From: Lewis, Trevor <Trevor.Lewis@lancashire.gov.uk>
Sent: 10 September 2014 15:10
To: Sarah Westwood
Cc: planning; ENV LHS Customer Service
Subject: 3/2014/0618 land off Chatburn Old Road, Chatburn

The application is for the erection of ten dwellings.

Title: Planning Drawings - Proposed Location Plan

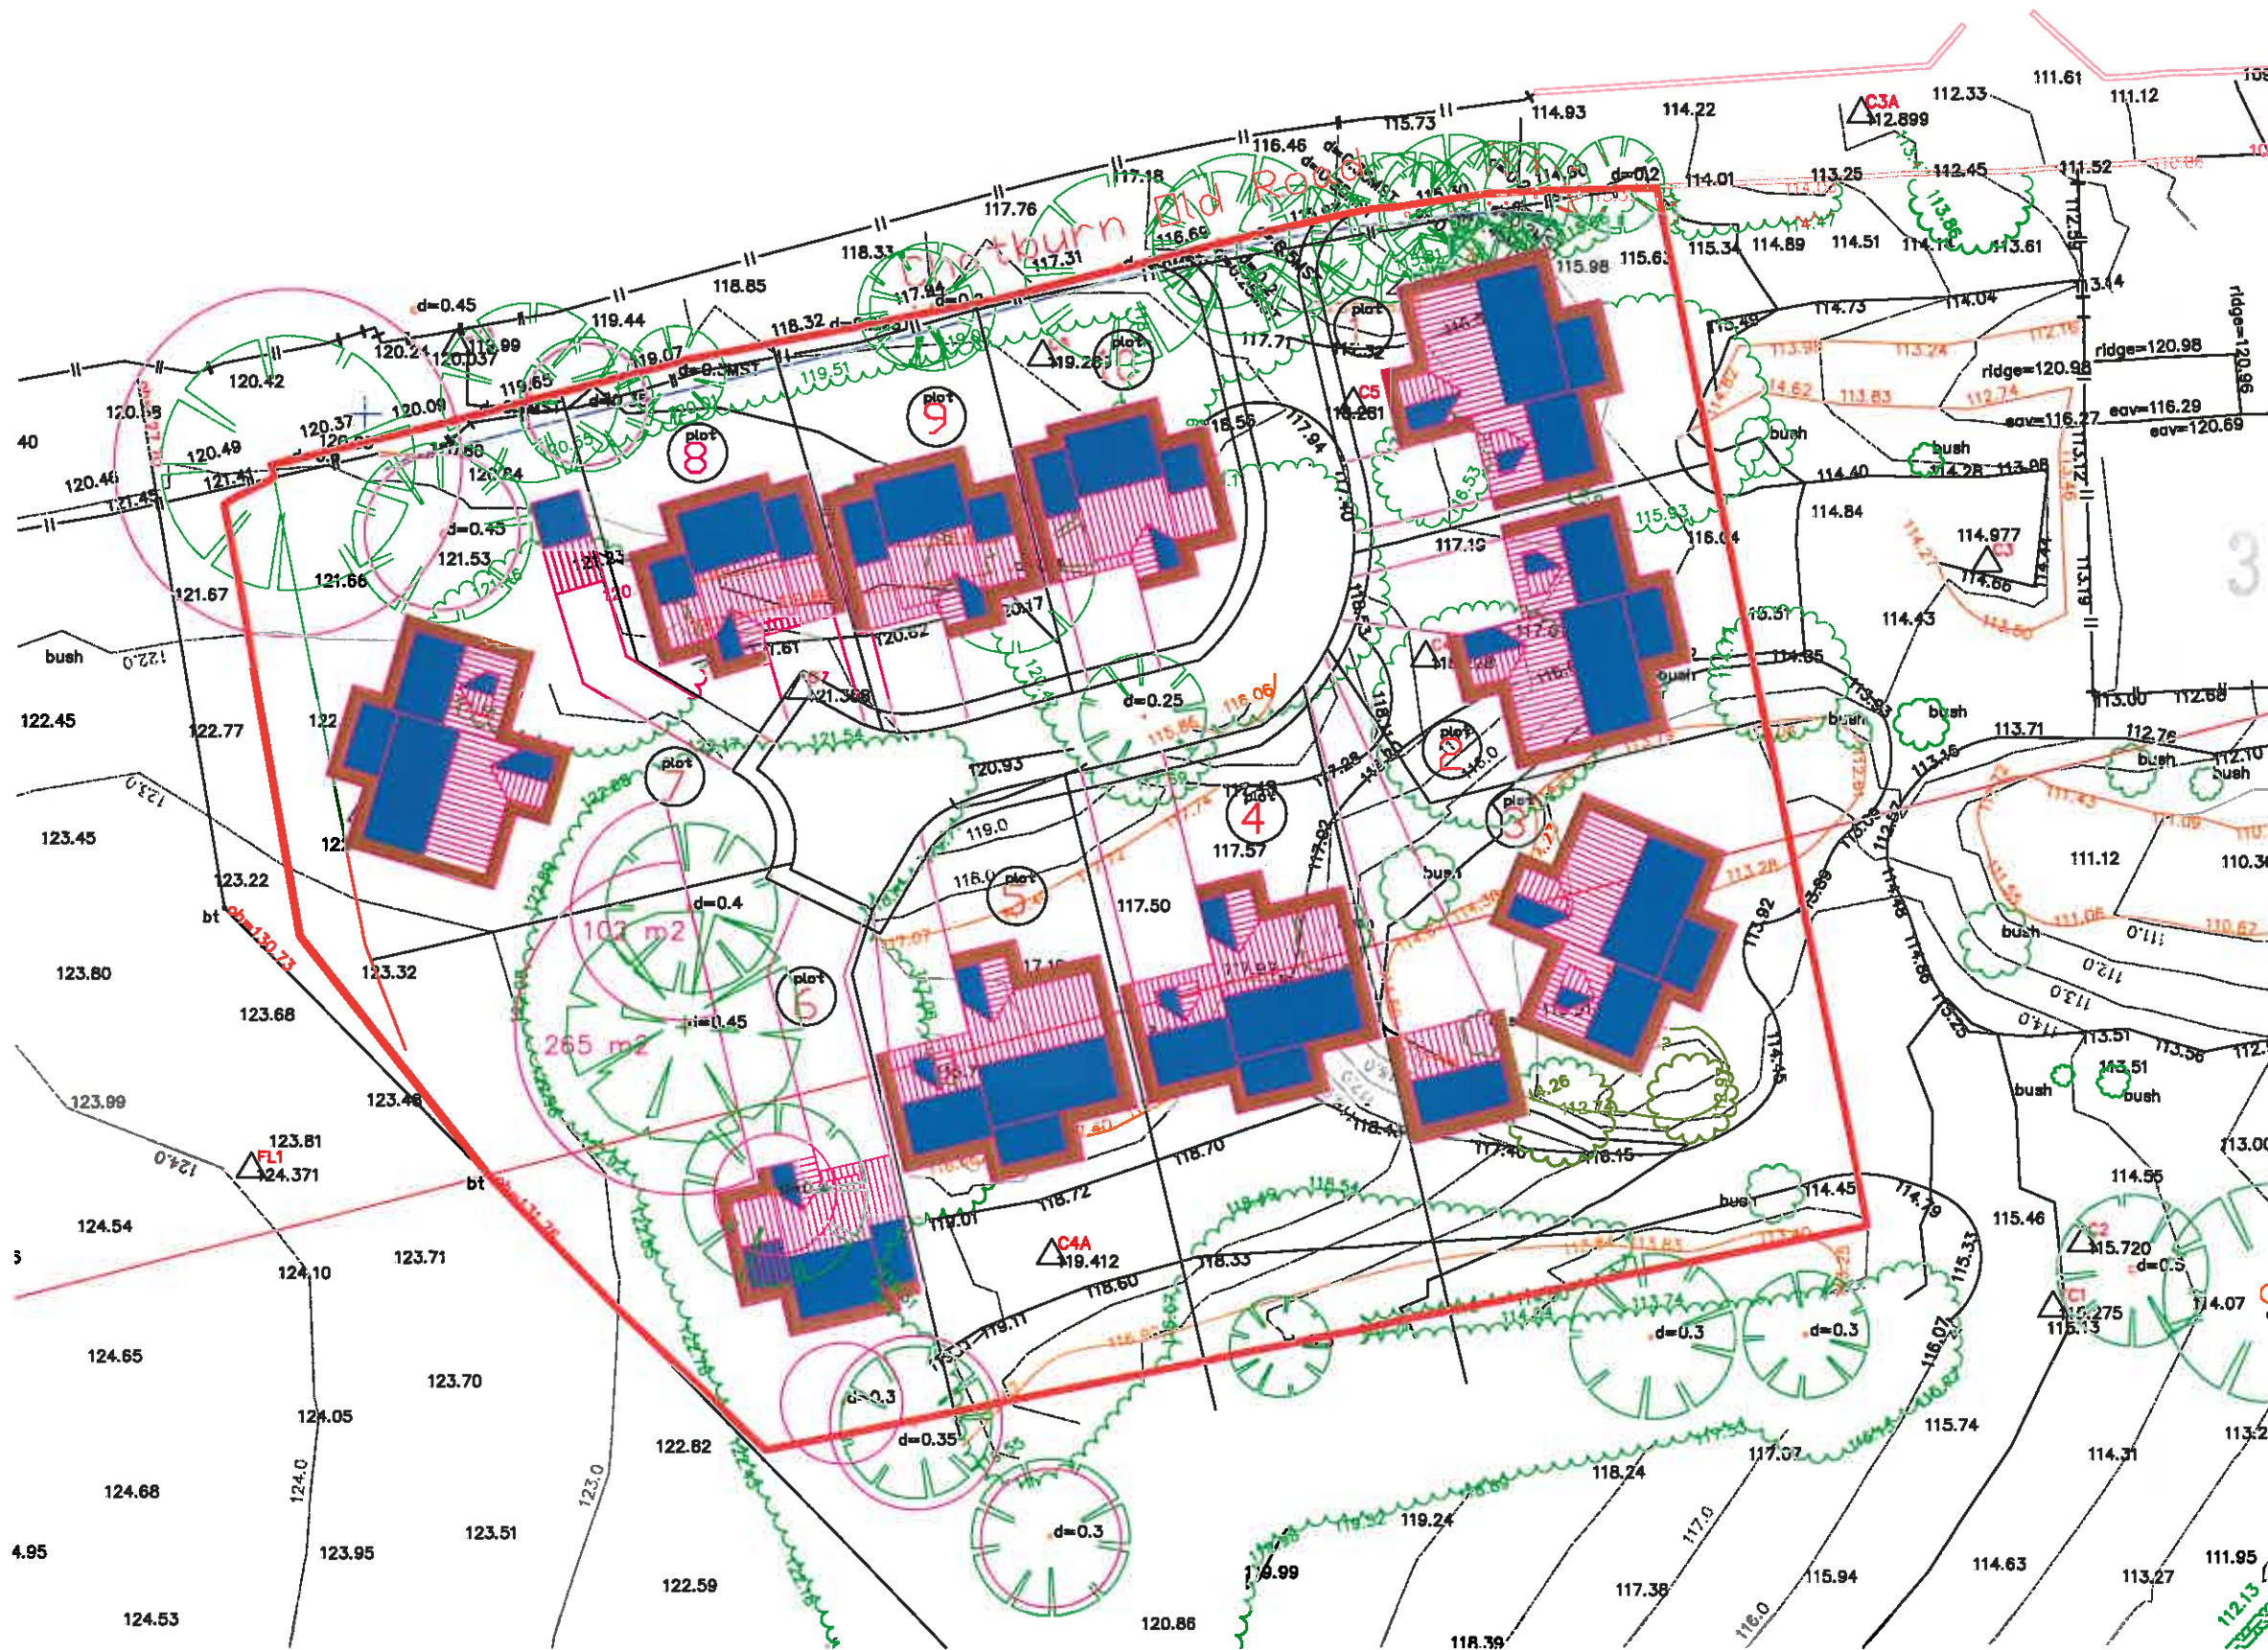
2. I would ask for the construction of a turning head on Chatburn Old Road before the end of the road near the quarry. This will require works in the highway under a S278 agreement. Some of the developers land will be required to create an appropriate turning head and this land will need to be dedicated as public highway.

3. The road leading up to the proposed estate road is unlit and I would require new street lighting columns at least to the new access.
4. There is no footway along Chatburn Old Road, and I do not intend to ask for one along the property road frontage. However I consider there will be a benefit in marking the edge of the carriageway and providing a space for pedestrians up to the public right of way (FP13). This should allow for a 5.5m carriageway width and a minimum of a 1.2m wide space for pedestrians. The width of the carriageway is not clear, due to the overgrown nature of the verge. Once this is known, the details of this road marking can be finalised.

I did previously ask (comment on pre-application enquiry) for barriers to be erected on the highway near the end of the public highway in Chatburn Old Road, because of the proximity of the edge of the quarry. However, the turning head may be sufficient to restrict vehicular movement further along the road towards the quarry. This would be reviewed when a drawing showing the improvements proposed are submitted for approval.
